City of Ottawa
Planning, Infrastructure and Economic Development Department
Planning and Infrastructure Approvals
Development Review, Central
110 Laurier Street West, 4th Floor
Ottawa, ON K1P 1J1

**Reference: 820 Miikana Road
Site Plan Control Application
Response to RMA Comments
Our File No.: 122054
City File No.: D07-12-22-0110**

LOCATION CITY OF OTTAWA 820 MIIKANA ROAD		PROJECT No. 122054
DRAWING NAME FUNCTIONAL DESIGN OF PROPOSED PARKING LAYBY		REV # 2
		DRAWING No. 122054-FD

Functional Design of Proposed Roadway Modification

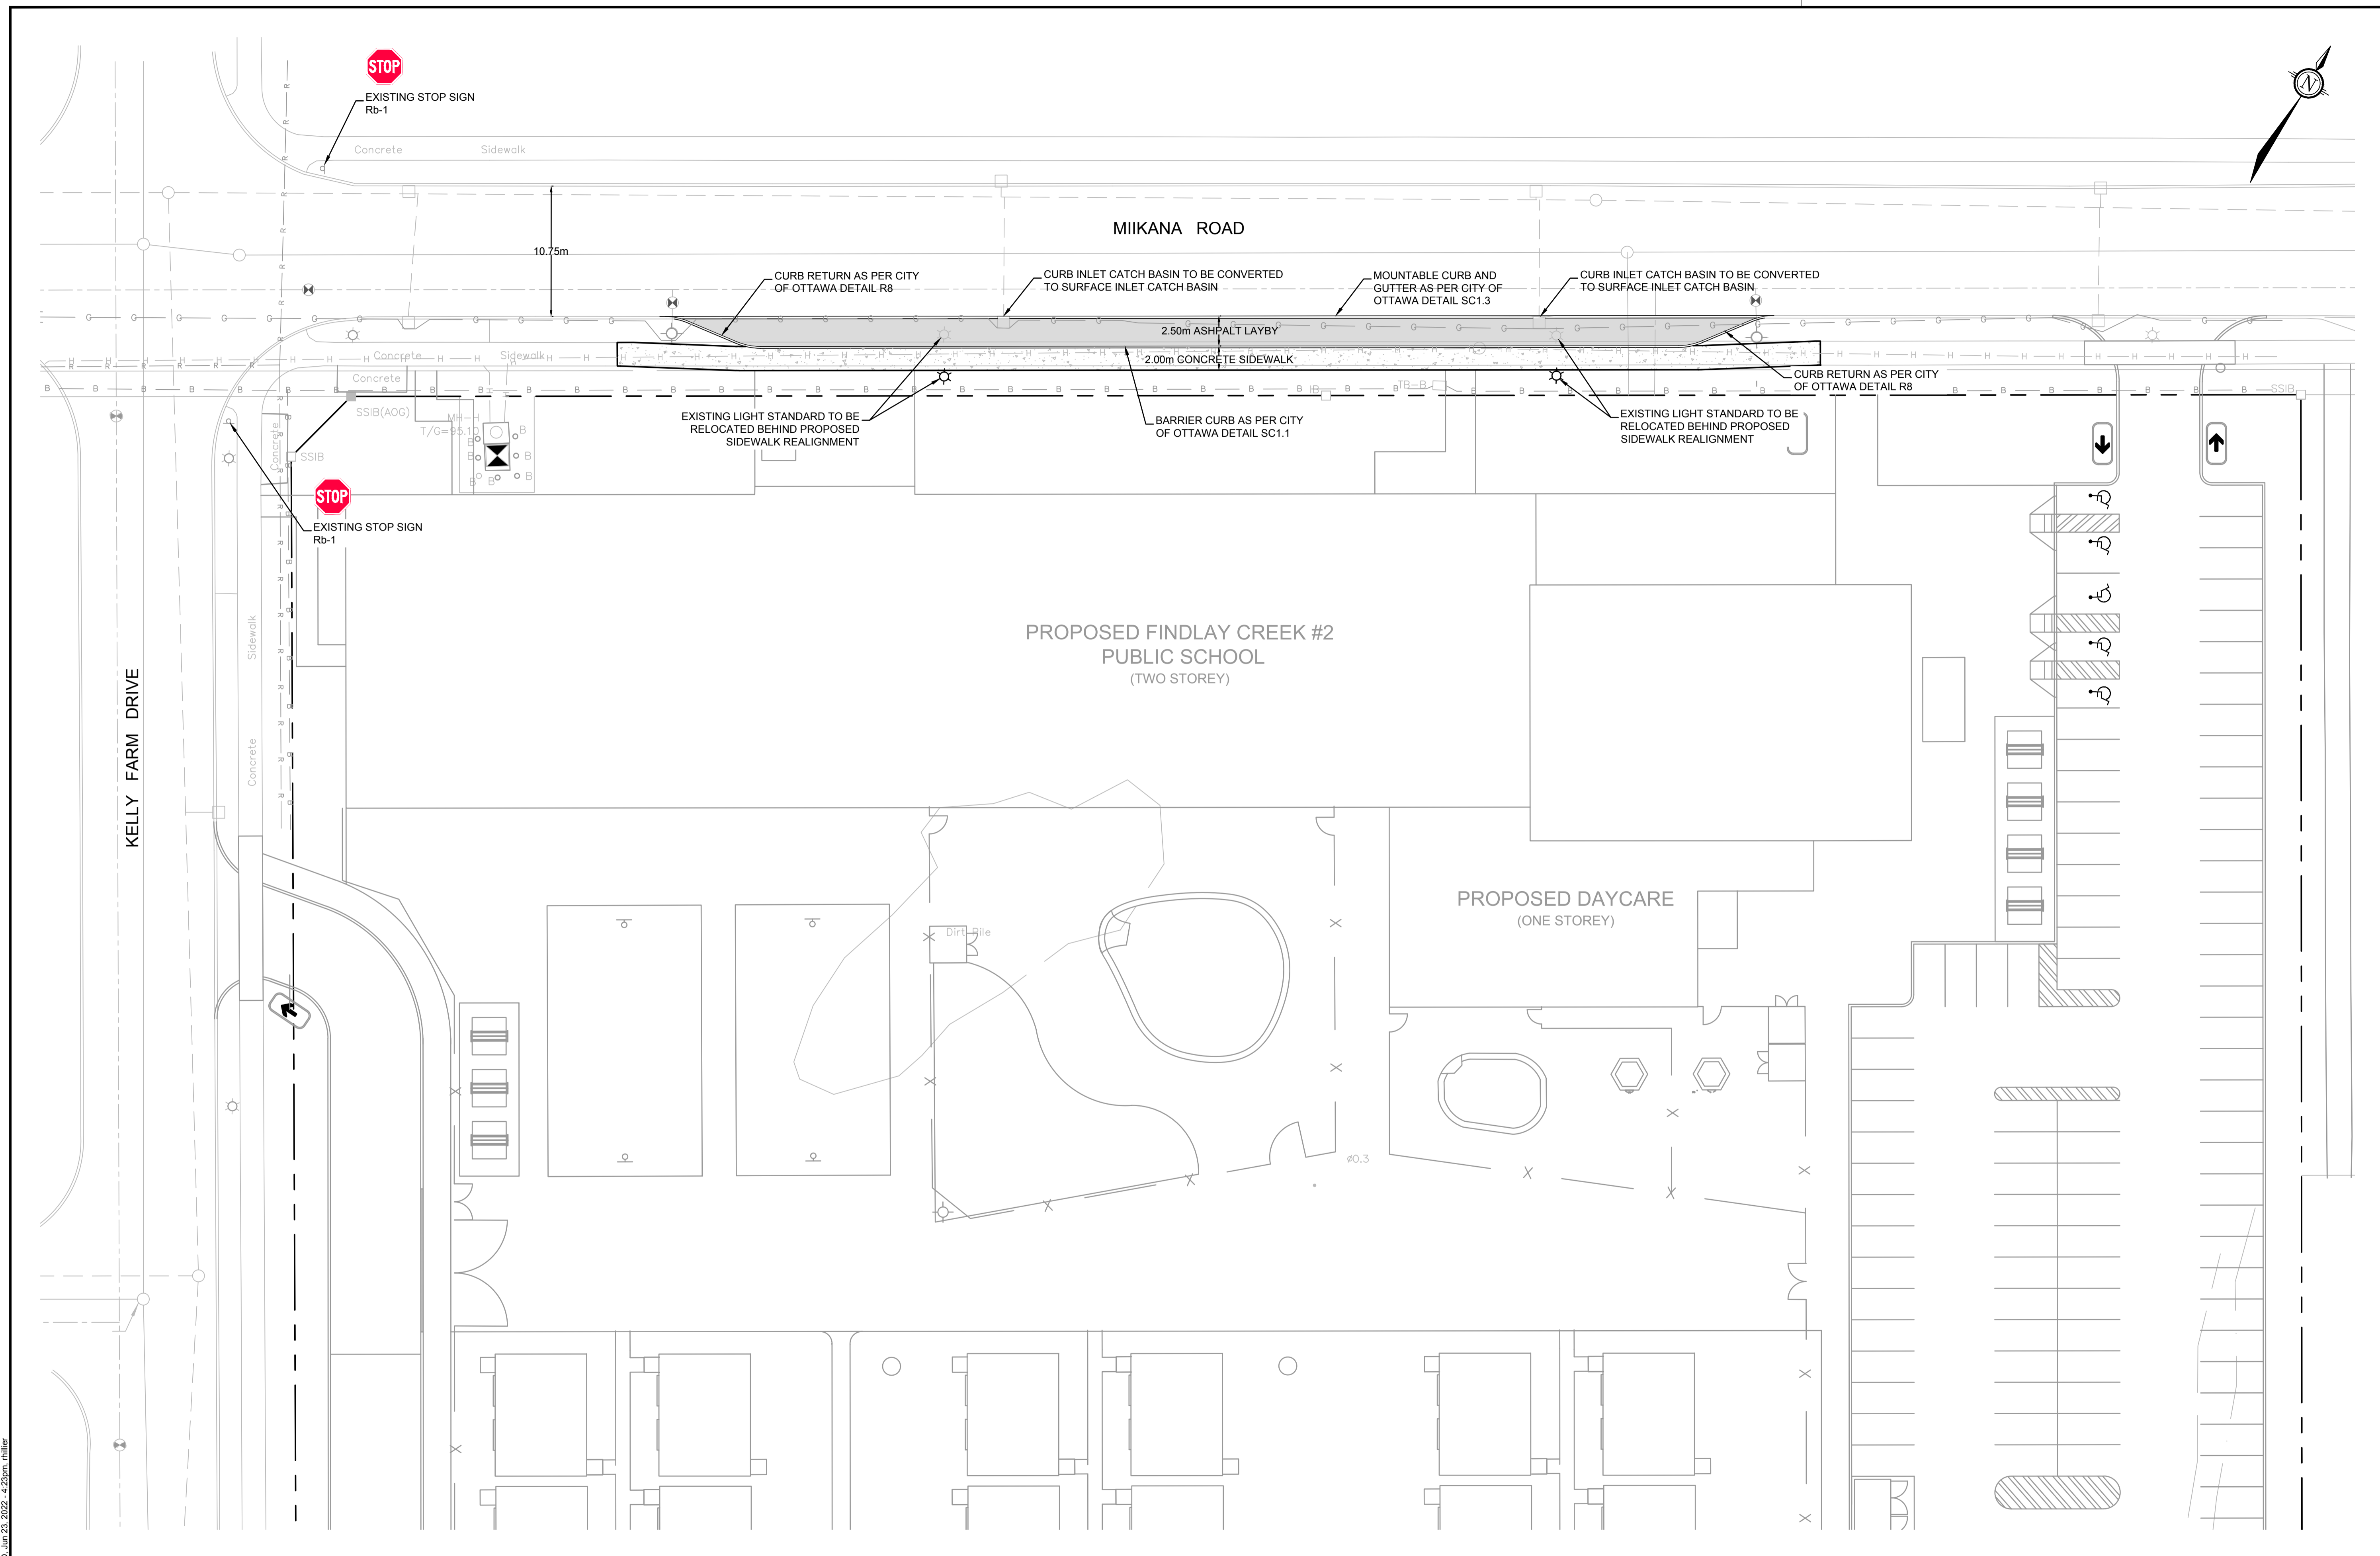
The lay-by functional design shows the existing Miikana Road is 10.75m wide (only slightly narrower than the old 11m standard where parking is often permitted on both sides). Therefore, consider re-signing the existing parking for pick-up and drop-off activities. Providing bulb-outs to frame the existing parking as a lay-by would also be encouraged/supported and be consistent with the Designing Neighbourhood Collector Streets document.

2. *“The lay-by will be directly adjacent to the sidewalk (i.e. no boulevard will be provided), so that students will not have to travel through any snow storage areas to enter/exit vehicles that are picking them up or dropping them off.”*

If this is the issue, consider filling in the existing boulevard with concrete (locally widen the sidewalk) to allow winter maintenance of the area.

Response – *The OCDSB has agreed to filling in the existing gravel boulevard between the two existing fire hydrants on the south side of Miikana Road (approximately 40m and 130m east of Kelly Farm Drive), and this approximately 90m-long section of Miikana Road will form the designated pick-up/drop-off zone. It is proposed that the signage prohibits on-street parking from 7:00am to 8:00am and 2:30pm to 3:30pm on weekdays. An updated Functional Design is included with this letter.*

It is understood that the City would encourage, support, or prefer bulb-outs to frame the pick-up/drop-off zone. However, the requested bulb-outs would result in significant additional work, including reconstruction of the existing sidewalk and bus stop pad at Miikana Road/Kelly Farm Drive and relocation of two catch basins. On this basis, the OCDSB prefers to maintain the existing cross-section of Miikana Road, and limit the proposed works to the boulevard.
